Subject: S08/0014908_0255 MP MOD 1 and 08_0255 CP MOD 1 - Proposed Modification to

Elf (formerly Tolson's) Mushroom Farm and Substrate Plant

I refer to your letter dated 18 March 2015 (Your Ref: S08/00149) regarding the proposed modification to the concept and project approvals issued for Elf Mushroom Farm and Substrate Plant at 112 Mulgrave Road, Mulgrave. The proposal has been reviewed by Council staff and comments for your consideration are provided below:

FIGURE 2 Existing and Approved Development

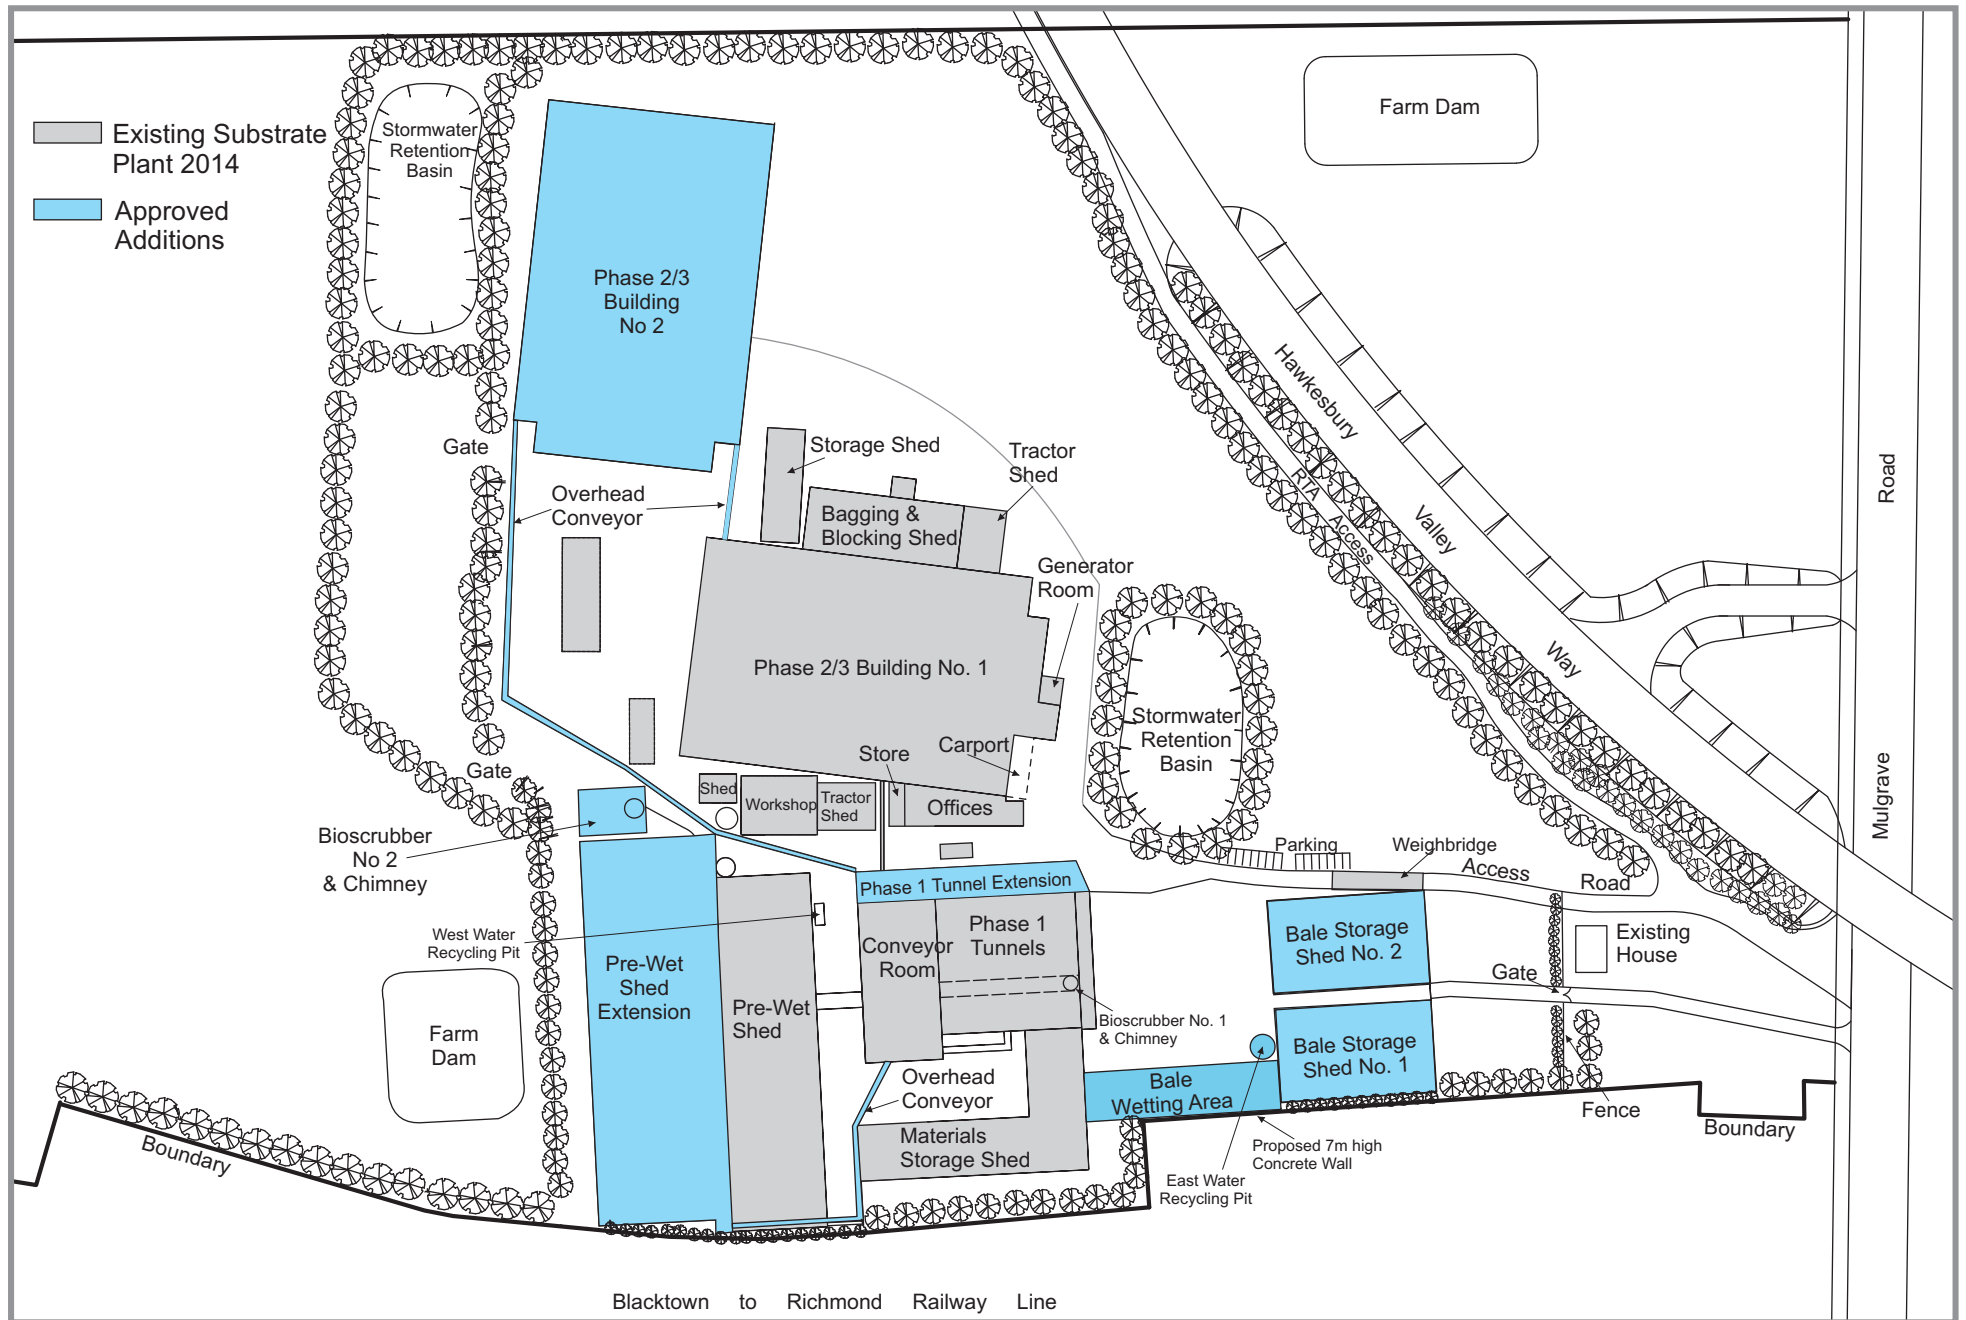
<u>Planning:</u> The proposed extension of the substrate plant extends beyond the IN2 Light Industry zone and into the RU4 Primary Production Small Lots zone. Substrate plants are defined as 'rural industries', which are a prohibited form of development within the RU4 Primary Production Lots zone. However, from our discussions it is understood that the repealed Section 75W of the Environmental Planning and Assessment Act 1979 can be used to address this permissibility issue.

FIGURE 5 Elevations

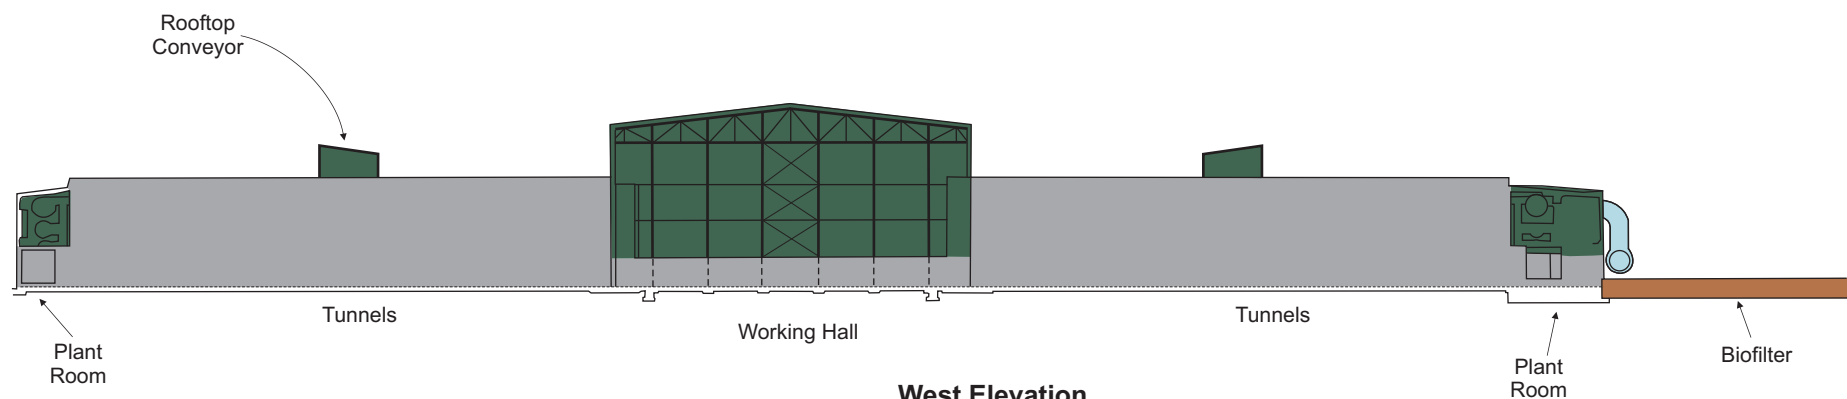
The prepared plans within the statement appear to be general and conceptual only. They do not include all elevations, any dimensions (heights, setbacks etc.) or any material details. Therefore the plans do not enable a full assessment of visual impacts nor do they establish a defined building envelope for construction.
